Your ref
P/30/26/OUT

Our ref
DSA000052510

Details: Outline application with some matters reserved, except access, for up to 120 No residential dwellings including means of access into the site (not internal roads). This application is a Departure from the Development and affects a Public Right of Way.

Site: Land North of Summer Lane, Pagham. West Sussex, PO21 3ND.

Figure 2: Pagham WwTW Layout Plan

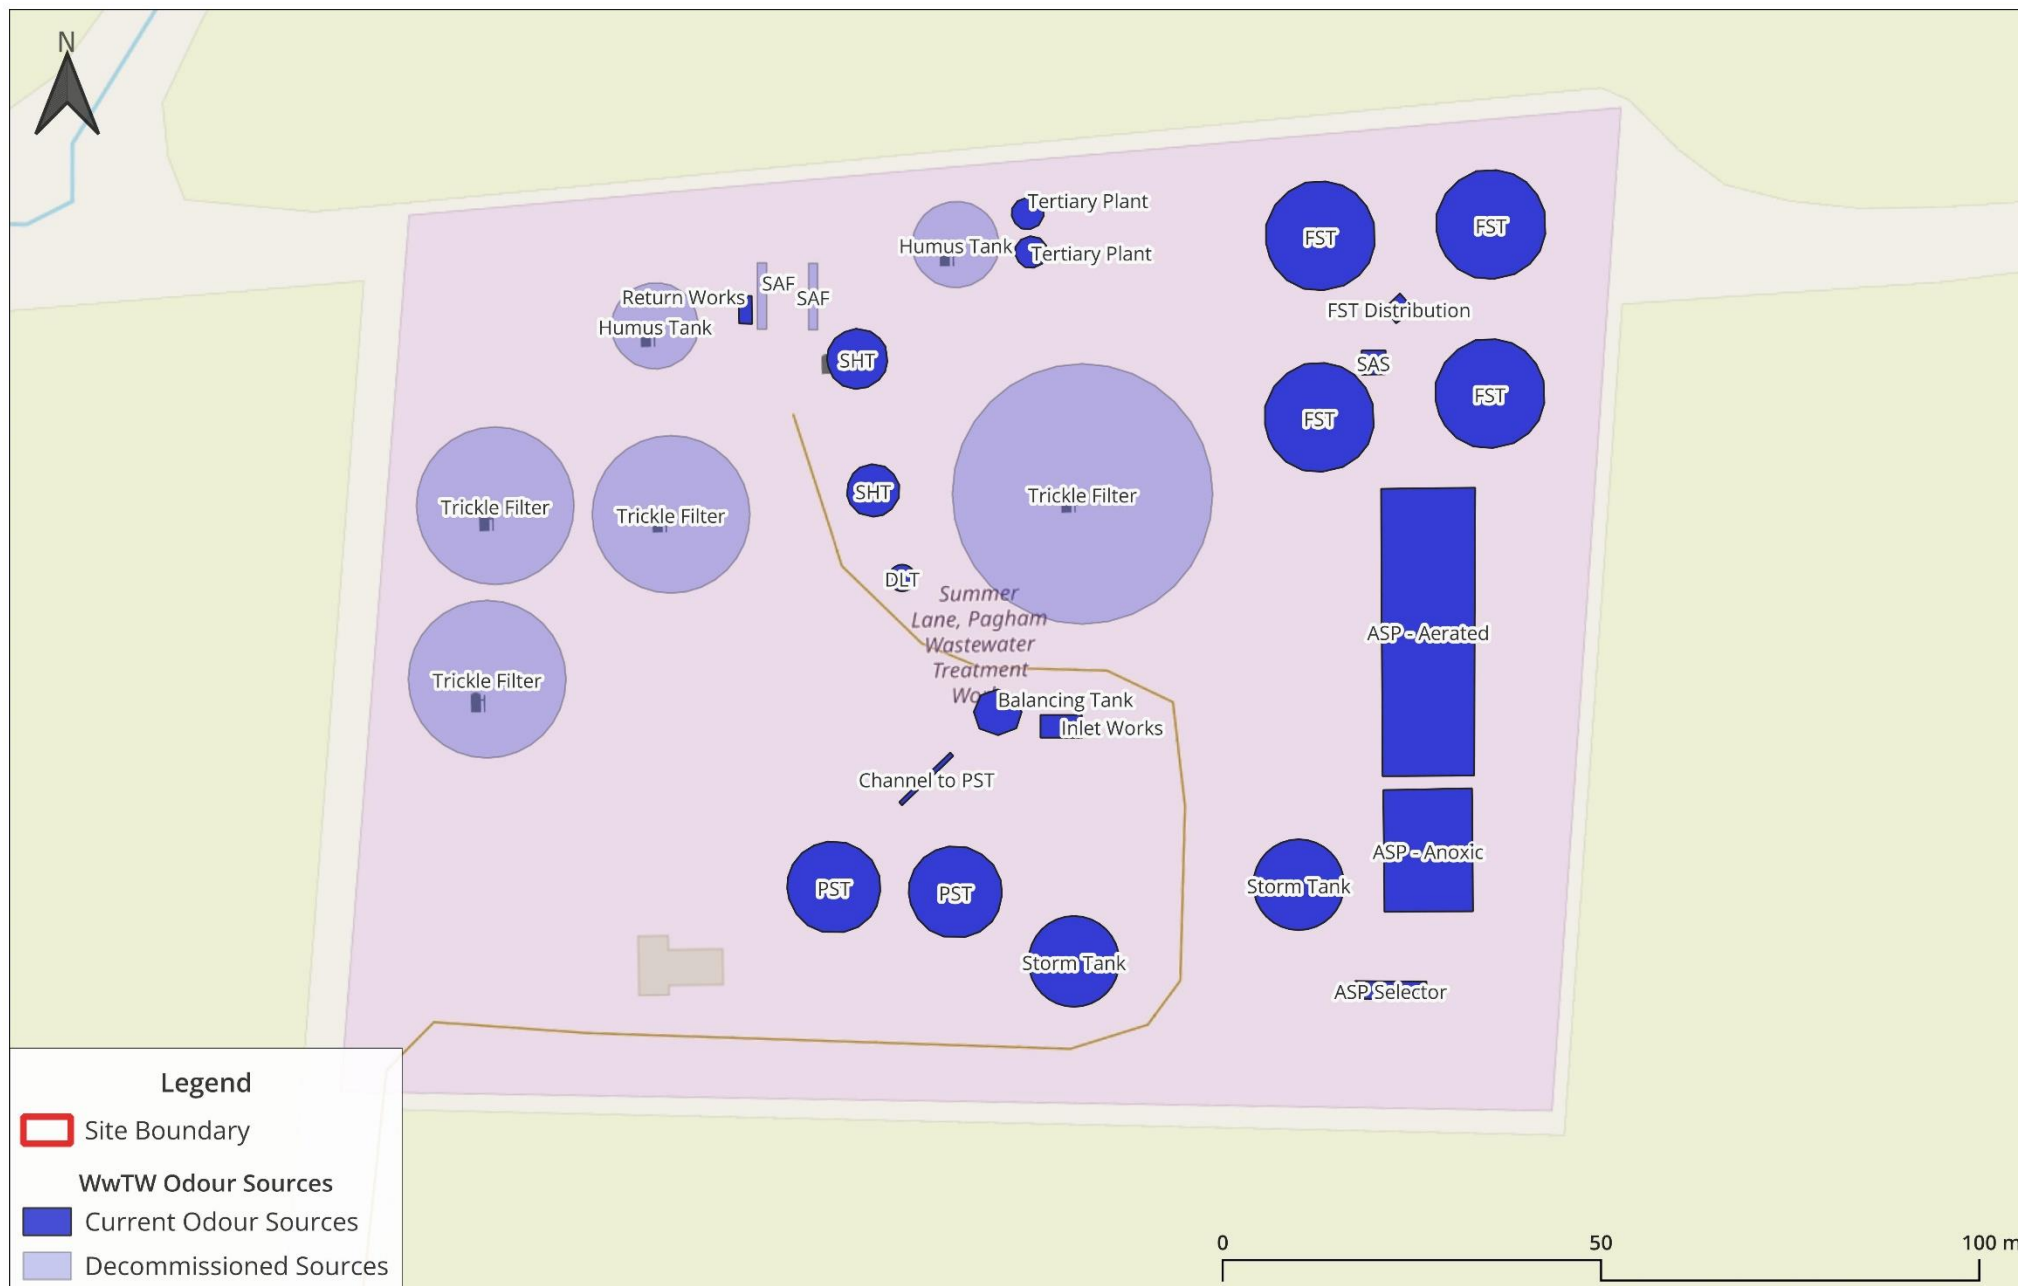
Existing Southern Water, Wastewater Treatment Works (WWTW) located in proximity to the proposed development.

In determining the application, we ask that the Planning Authority take into account the provisions of Paragraphs 180, 182 and 183 of the National Planning Policy Framework (NPPF) regarding the proposed location of development in relation to existing uses that may be a source of pollution (in terms of odour). We apply a precautionary buffer zone for any development located within 500 metres of the boundary of a WWTW. The proposed development is located approximately 300 metres from the Summer Lane Pagham Wastewater Treatment Works, and as such we have applied this requirement to our planning consultation response. Please contact Southern Water to discuss and agree the Scope of the odour assessment.

The outcome of the Odour Assessment should inform site layout, and any appropriate odour mitigation identified and agreed with Southern Water as necessary to avoid potential odour nuisance to future residents will also be funded by the developer.

Southern Water applies a target standard of 1.5 ouE/m³ as the 98th percentile of hourly averages contour to sensitive receptors in line with the NPPF recommendation for planning decisions to achieve a high standard of amenity for existing and future users.

Until a suitable and robust assessment demonstrates otherwise, due to the potential odour nuisance from a Wastewater Treatment Works, no sensitive development should be located within 500m of the WwTW site boundary. An Odour Assessment will need to be carried out by a specialist consultant funded by the developer to a scope that will need to be agreed in advance with Southern Water.
